**Reinforcement to the North Shropshire
Electricity Distribution Network**

**Statement of Common Ground
Between SP Manweb PLC and Canal and River
Trust**

PINS Reference EN020021

### **Montgomery Canal Crossing**

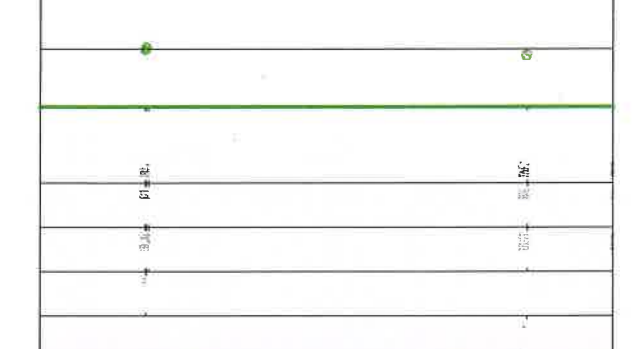
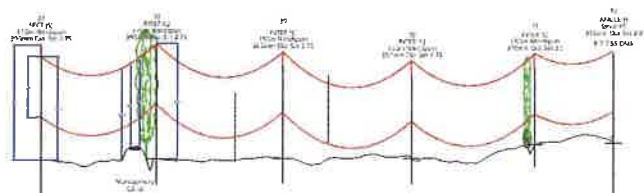
Commented [TB15]: There is no Annex A – this needs to be added so that we can agree.

Ref	Matters agreed
1	
2	SP Manweb and the Canal and River Trust AGREE the proposed design of the overhead line across the canal and canal towpath exceeds the stated minimum clearance distances for this type of overhead line design, as shown on the x-section drawing in Annex A attached to this SOCG.
